WEST SUSSEX COUNTY COUNCIL CONSULTATION

TO:	Arun District Council FAO: Maria Tomalova
FROM:	WSCC - Highways Authority
DATE:	24 February 2020
LOCATION:	Land off Canal Mews, Barnham, PO22 0AB
SUBJECT:	BN/66/19/PL Erection of 2 No dwellings.
DATE OF SITE VISIT:	N/A
RECOMMENDATION:	Advice
S106 CONTRIBUTION TOTAL:	N/A

Studio Lack Architecture Studio Lack Ltd : 17 Beech Avenue : Chichester 01243 782 686 : nicholas.lack@live.com : PO19 3DR	Land off Canal Mews Barnham	Site Layout 11/01/20 1/200 @ A3	Dwg 1705-12H
--	--	---	---------------------

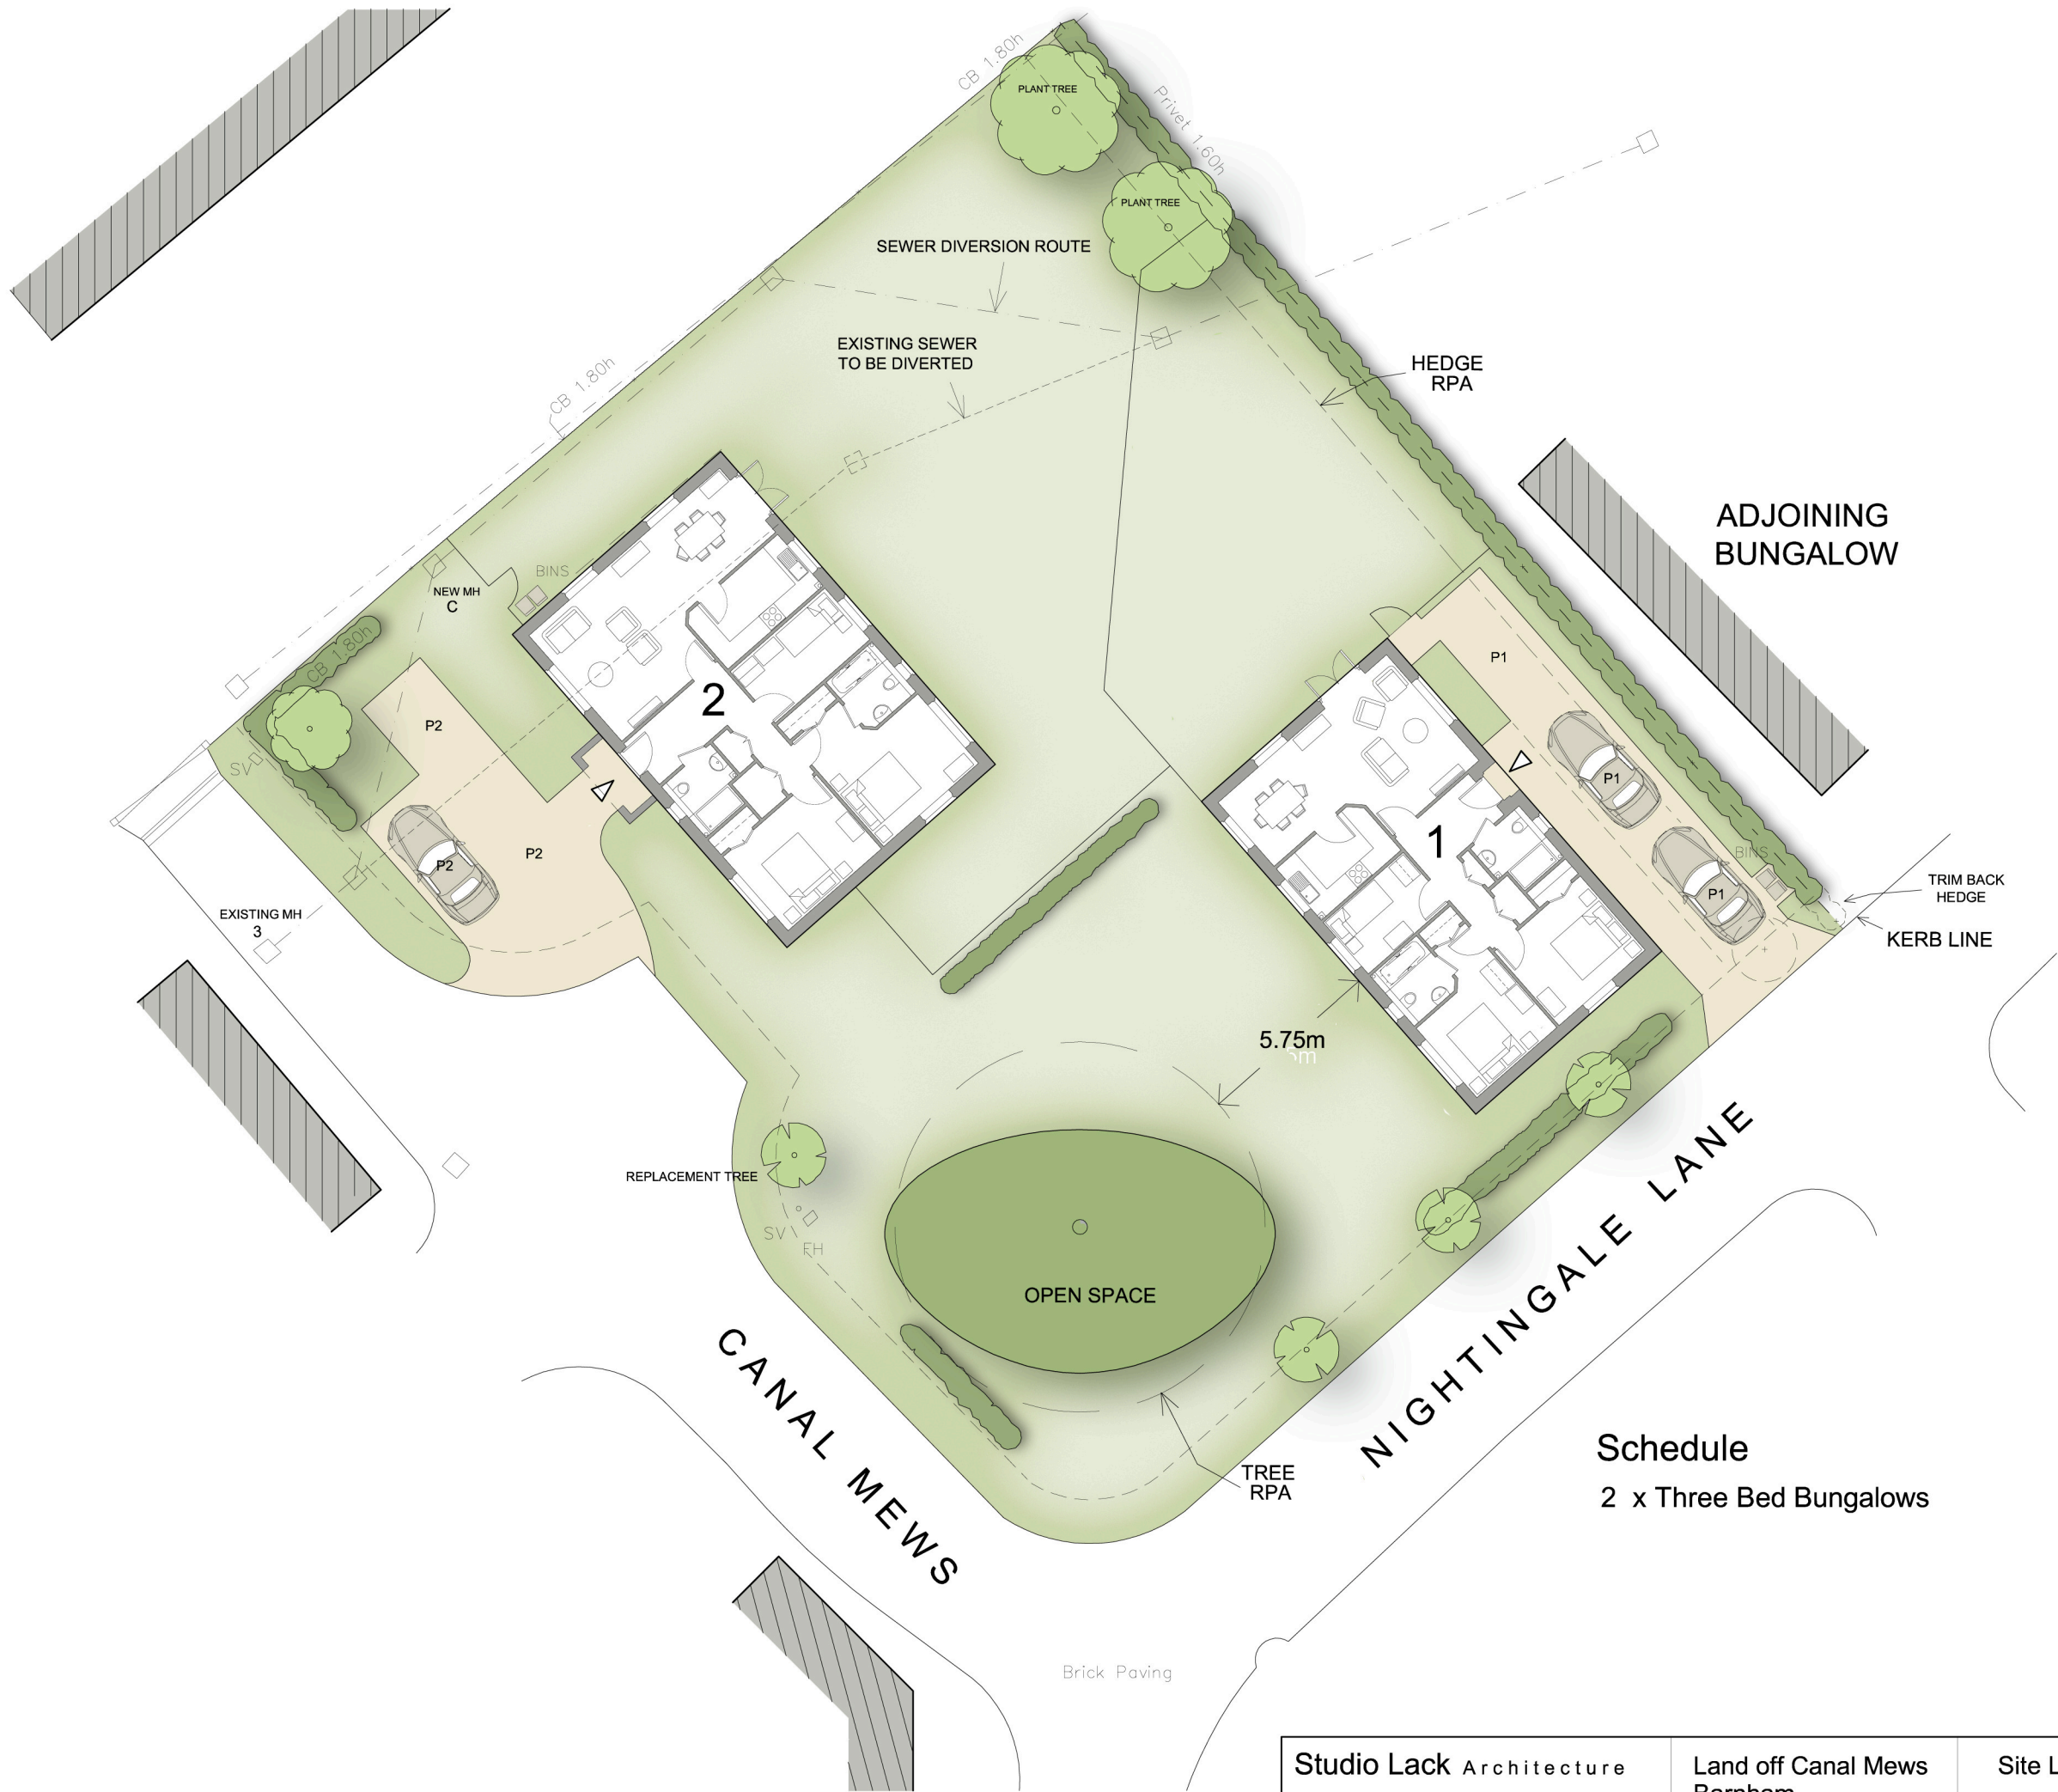
The applicant proposes a new access off Nightingale Lane to serve Plot 1, whilst Plot 2 will utilise an existing access on Canal Mews. The LHA advises the applicant to contact the proprietors of Canal Mews and Nightingale Lane to obtain formal approval for the access works on the privately maintained roads.

Substitute plans have demonstrated a parking provision of three spaces per dwelling, totalling to six spaces for this development. Under Arun Parking Standards (adopted January 2020), the LHA anticipate that four parking spaces would be sufficient for a development of this size and location.

The parking areas are of sufficient size to allow all parking bays to meet the minimum specifications of 2.4m x 4.8m as set out in Manual for Streets (MfS). On-site turning will not be achievable, so vehicles may have to exit the site in a reverse gear.

The applicant has not demonstrated cycle parking in the substitute plans. Arun and WSCC standards for new developments require residential dwellings with two bedrooms to provide cycle parking provision for at least one cycle and three-bedroom dwellings to provide provision for at least two cycles.

No part of the development shall be first occupied until the car parking has been constructed in accordance with the approved site plan. These spaces shall thereafter be retained at all times for their designated purpose.

No part of the development shall be first occupied until covered and secure cycle parking spaces have been provided in accordance with plans and details submitted to and approved by the Local Planning Authority.

The applicant is advised to contact the proprietors of Canal Mews and Nightingale Lane to obtain formal approval to carry out the site access works.
